Re: University of Sheffield AMRC PND Modification

LPA Reference: Ribble Valley Borough Council JM/3/2019/1061

South Ribble Borough Council 07/2019/12212/LDO

I write with regards proposed amendments sought to be made to the above mentioned approvals of development associated with The University of Sheffield's Prior Notification of Development (PND) submissions for the Advanced Manufacturing Research Centre (AMRC) North West (NW) facility at the Lancashire Advanced Engineering and Manufacturing Enterprise Zone (Samlesbury).

**Drawing Status**  
 For Planning

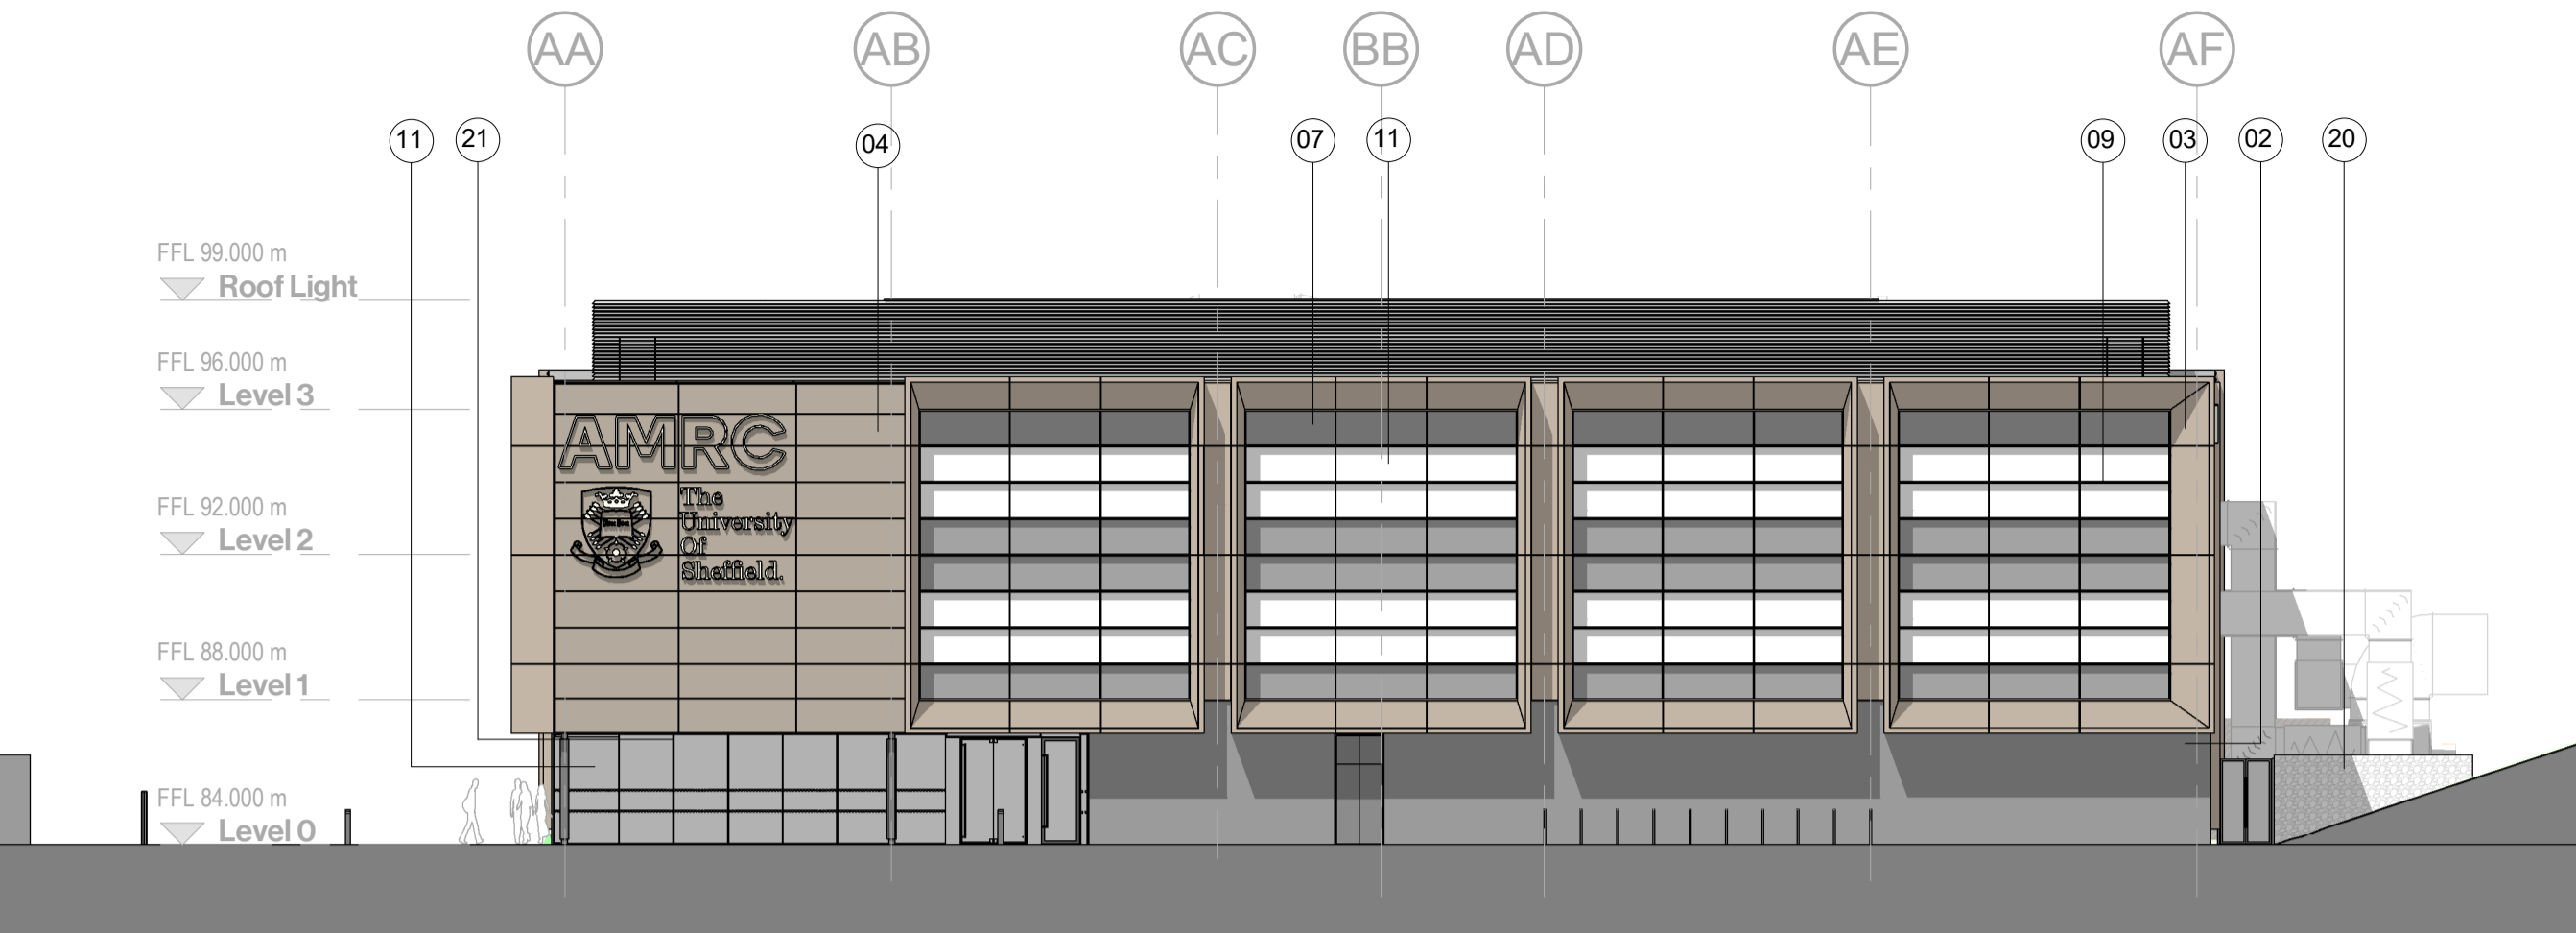
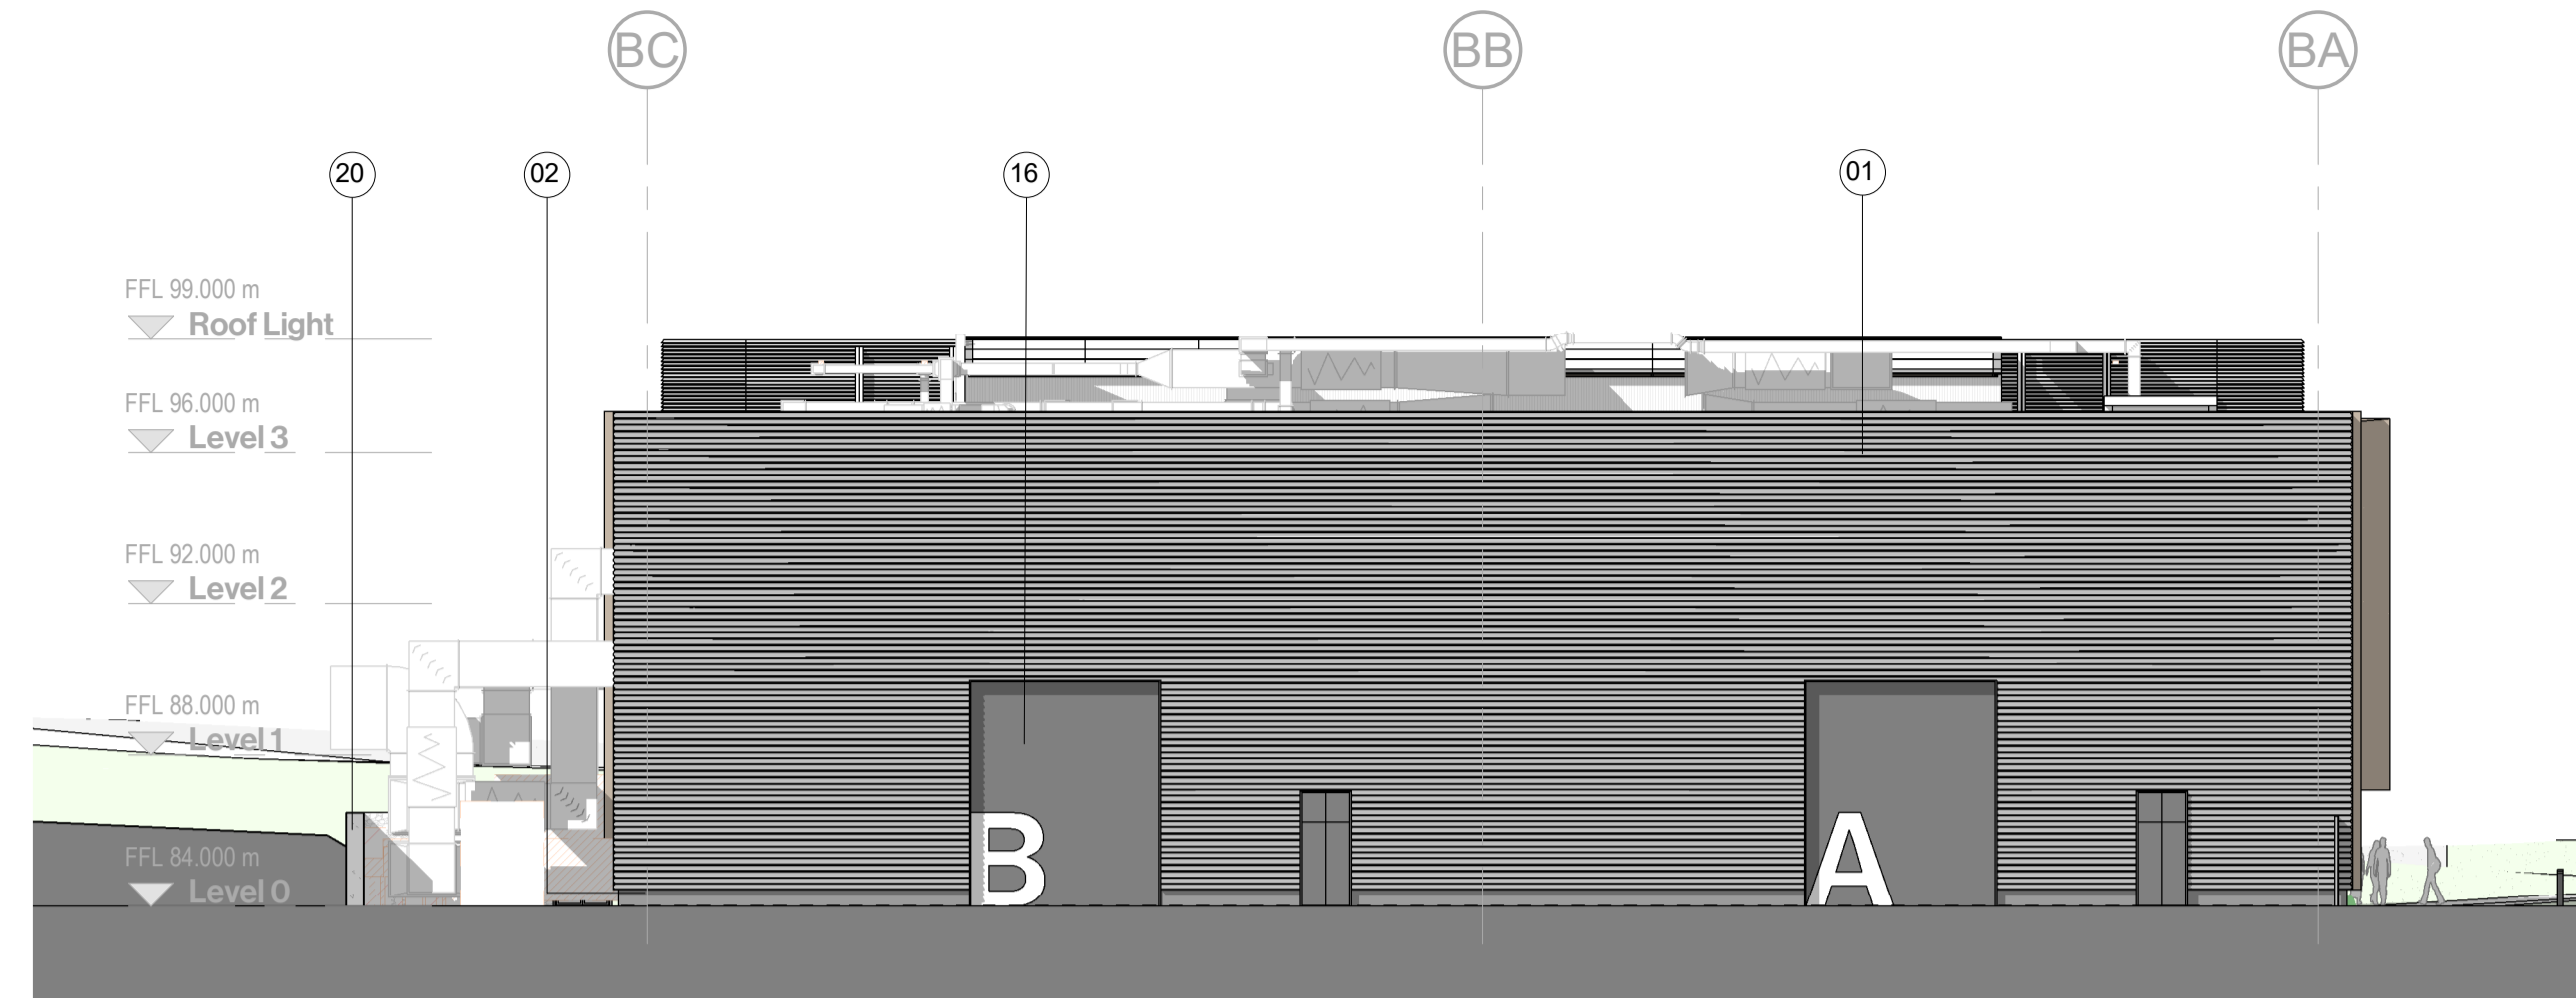
- The separation between the projecting bays have been omitted.
- The bay projections are reduced to 750mm from 1500mm.
- Slot windows and rooflights have been removed from the workshop area to create controlled environment.
- Vertical fins are now used to break down the mass of the workshop elevations.
- There is a reduction in tree planting with the focus on landscaping screening the car park and removing trees from swales.
- Hardstanding has been reduced and the service yard corner has been replaced with wildflower planting.

The 3D visuals and elevation treatments and demonstrate that the key architectural features, such as the south framing are retained and the revised scheme aligns with the original architectural aspirations for this gateway site. The original materials have been retained and rationalised, although it has now been established that that the workshop area is required to be a 'black box' controlled space which has required design amendments.
